Project Name: Park Danforth

Project Address: 777 Stevens Ave.

February 11, 2015

Project Name: The Park Danforth                      Project ID: 2014-202  
Address: 777 Stevens Avenue                      CBL: 146 C005 001  
Applicant: The Park Danforth- Denise Vachon  
Planner: Shukria Wiar

Drawing file: 4. Revised Plans / L3.2 ESC 11-25-2014.pdf

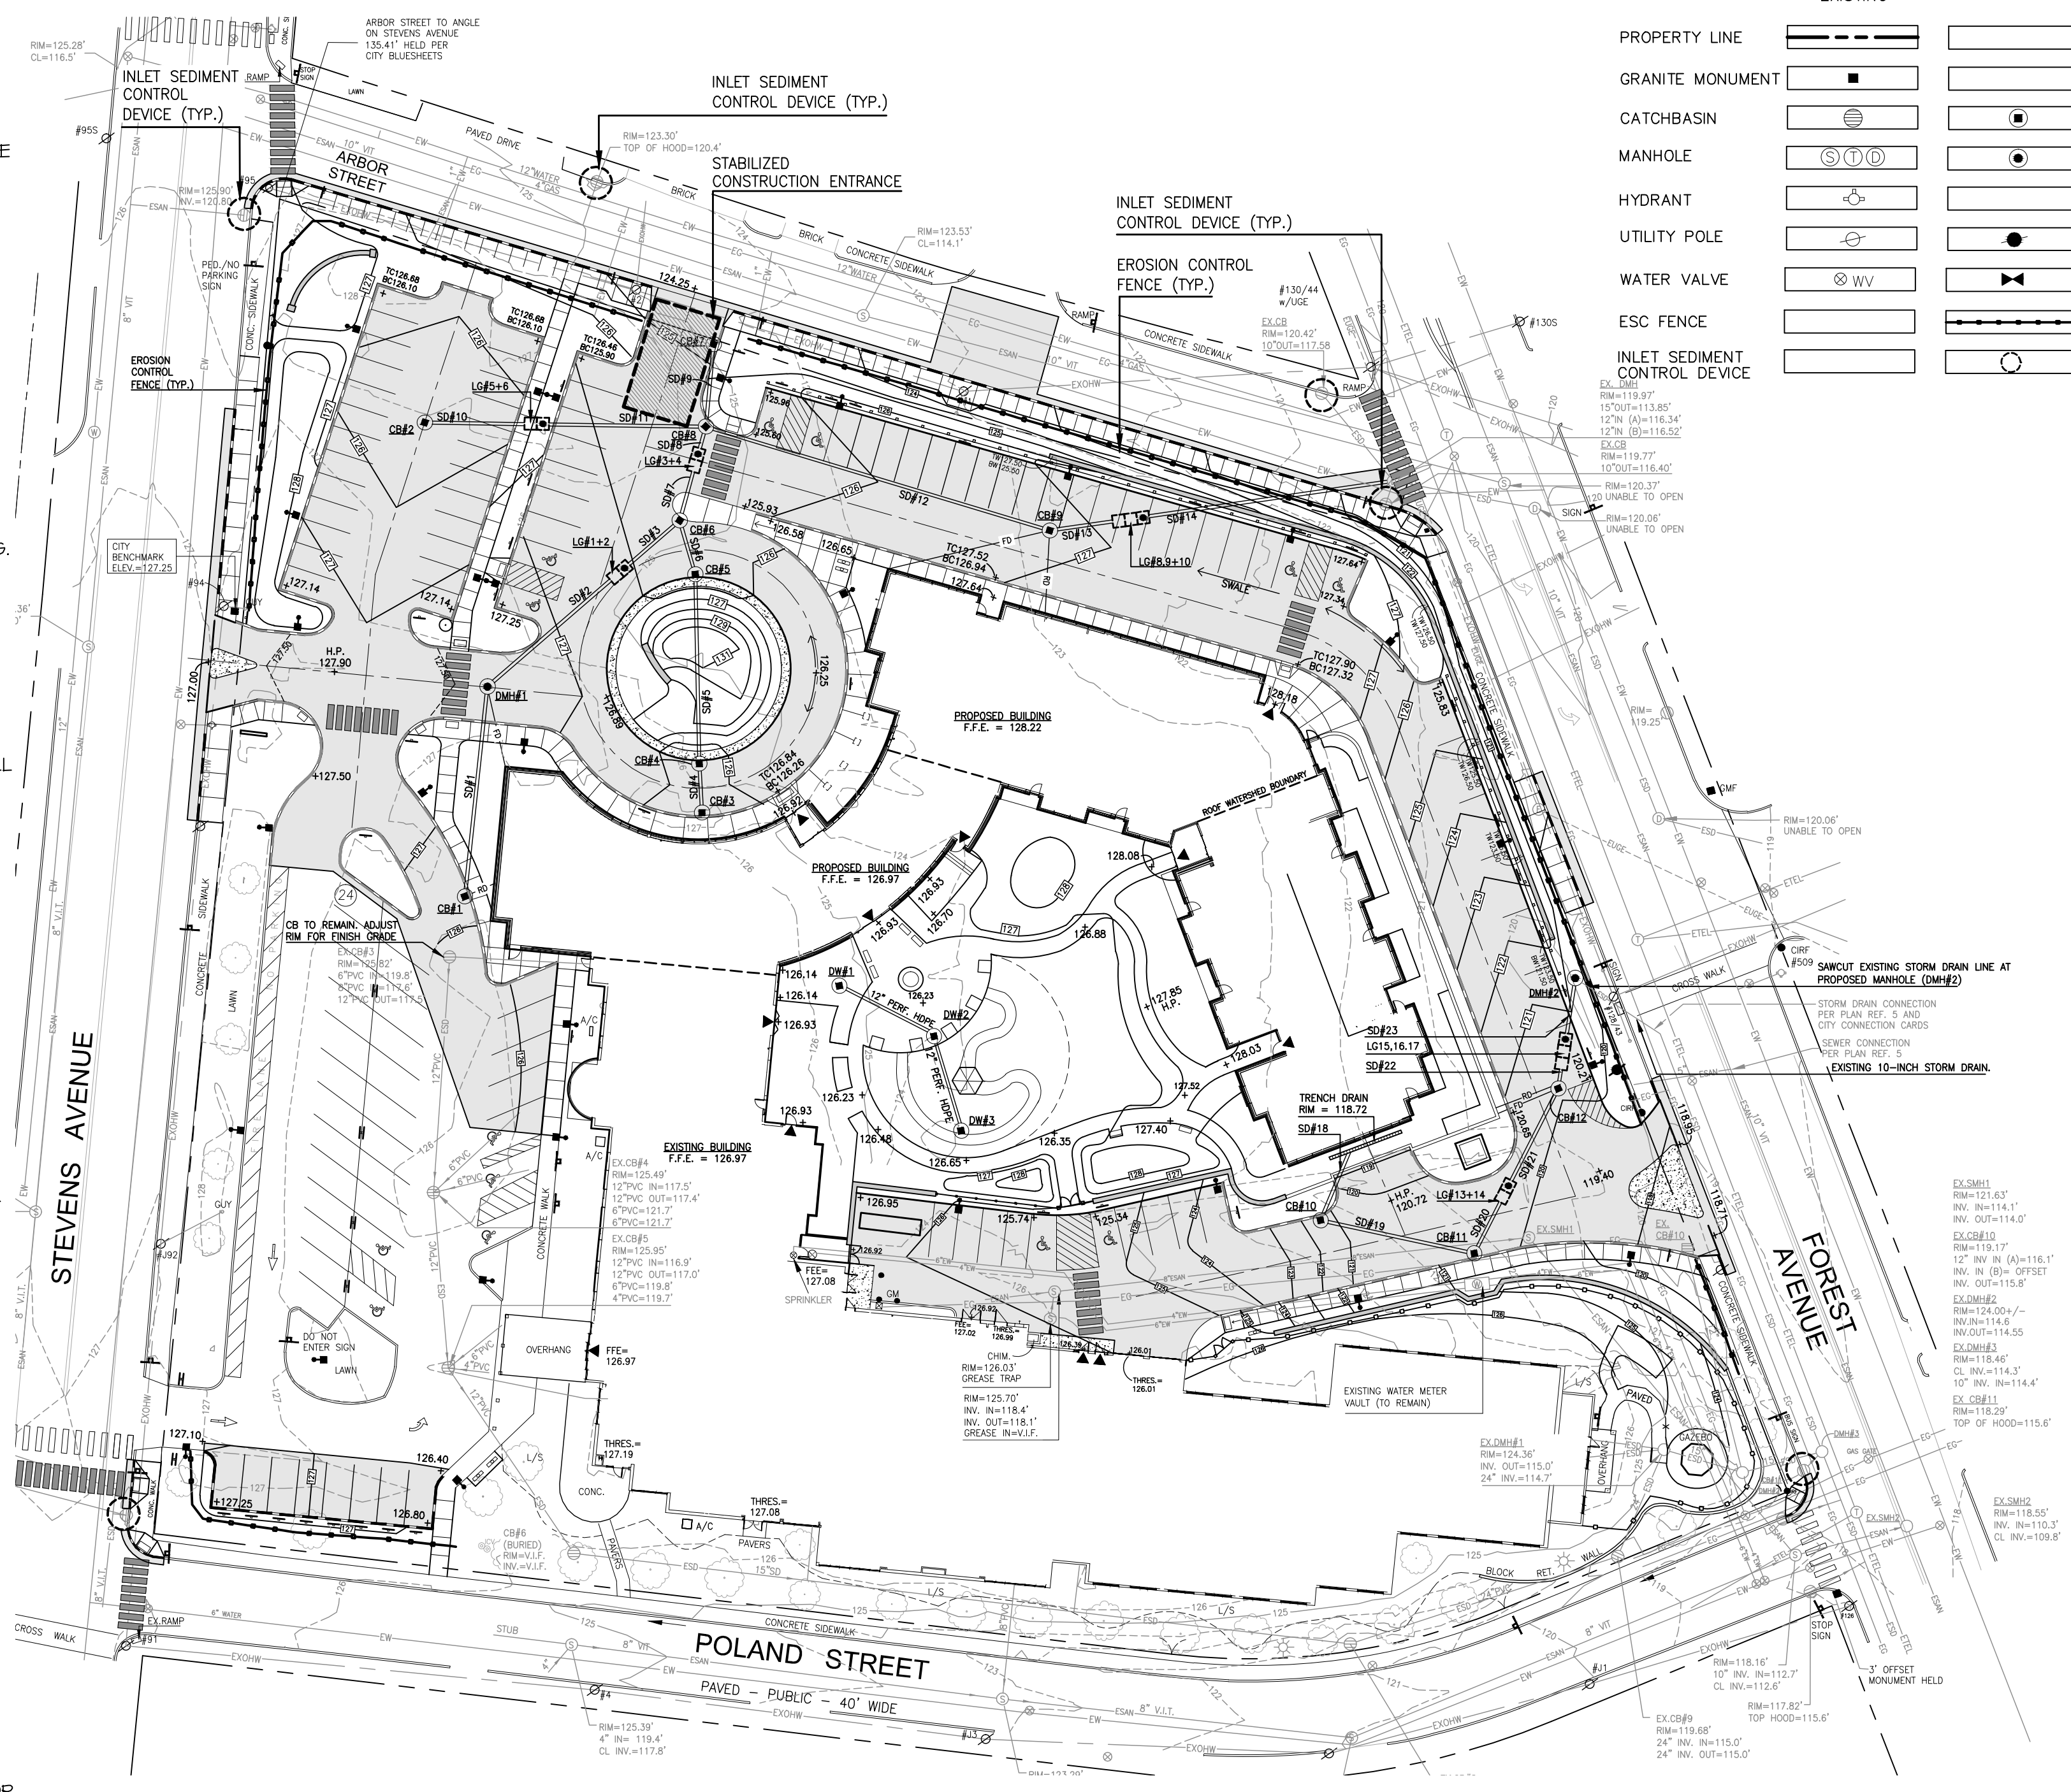
3. The Erosion and Sediment Control Plan (L3.2) shall be revised to identify an inlet sediment control device on existing CB# 4.
4. The note on the Snout detail shown on Sheet L6.2 which states "The Snout shall be provided on Proposed Catch Basins #6100, #6101 and #6102"; shall be deleted from the revised plans.
